SITE BLOCK PLAN
SCALE 1:500

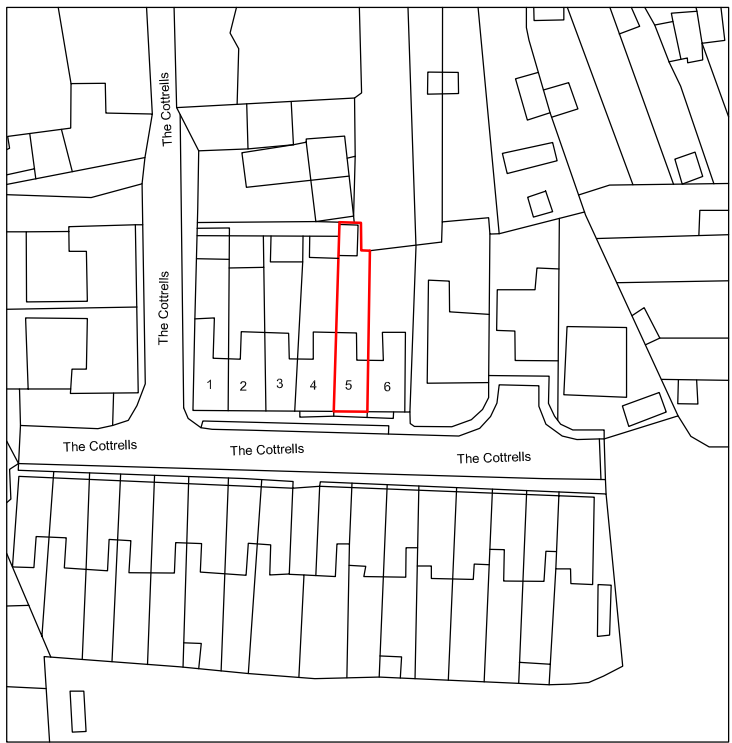
- Location Plan: Please submit an up to date location plan. This plan should be an ordnance survey type plan at an identified standard metric scale, typically 1:1250 or 1:2500. The plan should show the site to which the application relates outlined clearly in red and should identify sufficient surrounding roads with an arrow showing the direction of north to illustrate the location. If you require assistance obtaining a location plan then you can visit the Planning Portal website (https://www.planningportal.co.uk/homepage/4/buy_a_plan) for links to where you can obtain one from

- Block Plan: The block plan does not measure to scale. This also requires the dimensions from the proposed works to all site boundaries. Along with this, the proposed office on the block plan measures inconsistently with the floor plans and elevations. Please review and amend.

1. Block Plan as a PDF scale 1:500 detailing the proposed building's position relative to the property boundaries
2. Elevation and Floor plan scale 1:50
3. Location Plan as PDF
4. Completed CIL as PDF
